**Submission in response to Sydney Metro's Westmead to The Bays and Sydney CBD
Environmental Impact Statement (SSI-10038)**

This submission focuses on the proposed Sydney Metro West station in Westmead and objections which have been raised by my constituents to the current plan. As State Member for Granville, I hold two critical concerns in regards to the released plan for the construction of the Metro West Network.

Figure 9-13: Westmead road realignment works

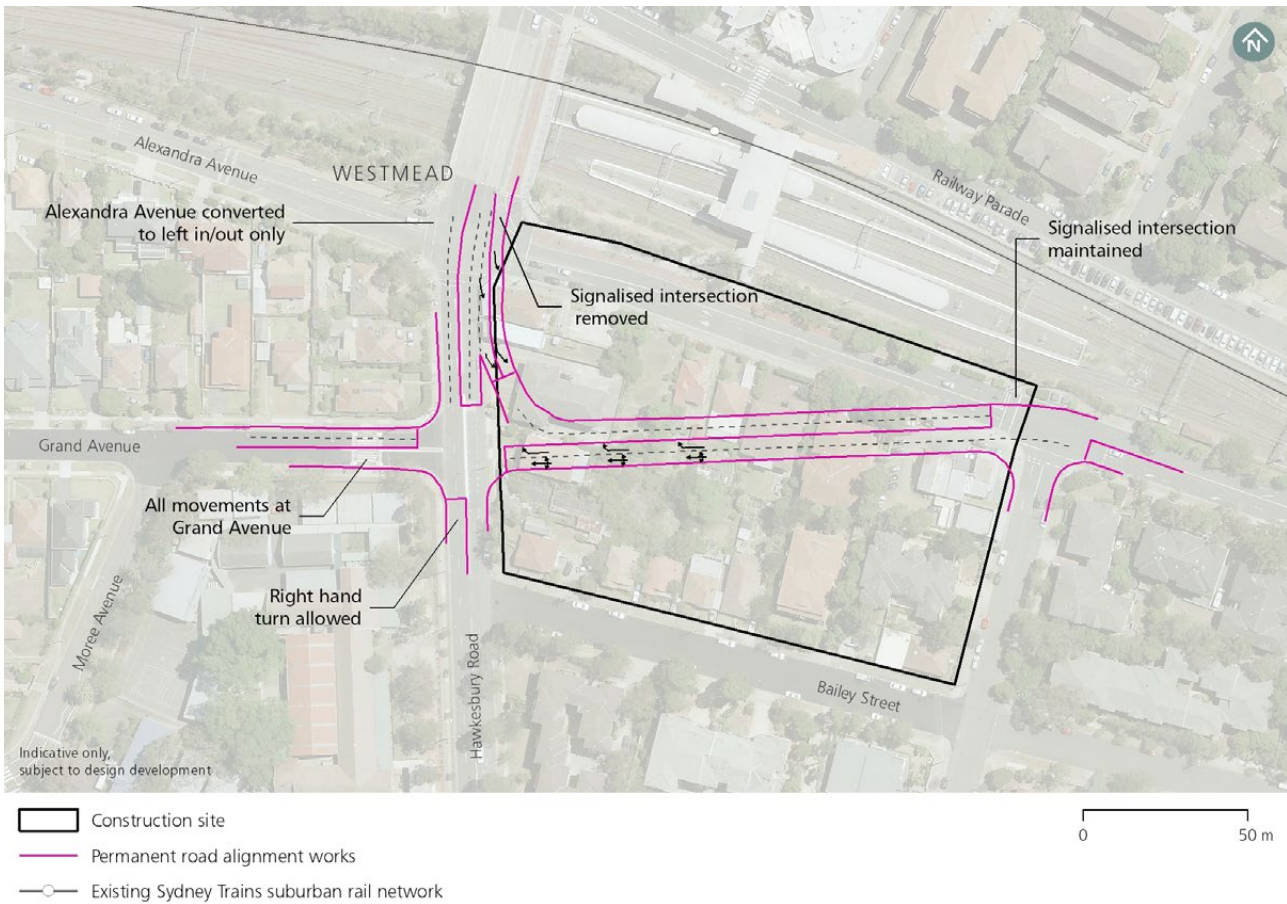
I hold concerns about the proposed use of Hawkesbury Road as part of the construction of Westmead Metro West station, and the effects this will have on essential traffic flow such as school bus routes and emergency vehicles. In the EIS, the preferred option for the construction of the Westmead Metro Station involves creating a new major intersection at Hawkesbury Road and Grand Avenue, turning Grand Avenue into a major thoroughfare with significant diversions of traffic resulting from the closure of parts of Hawkesbury Road.

I and many of my constituents are concerned that this will lead to reduced access for emergency vehicles, school buses and also have significant and detrimental impacts on Westmead Public School, the health and safety of its students, parents and staff.

The proposed use of Hawkesbury Road, Westmead as part of the construction of the Westmead Metro Station, creating a new major intersection at Hawkesbury Road and Grand Avenue, and turning Grand Avenue into a major thoroughfare will have significant effects on Westmead Public School. This change to traffic flow, coupled with the fact that Westmead Public School is located less than 50 metres from the proposed construction site, will have detrimental outcomes for students, parents and staff's health and safety due to excessive traffic, excessive noise levels and excessive dust levels.
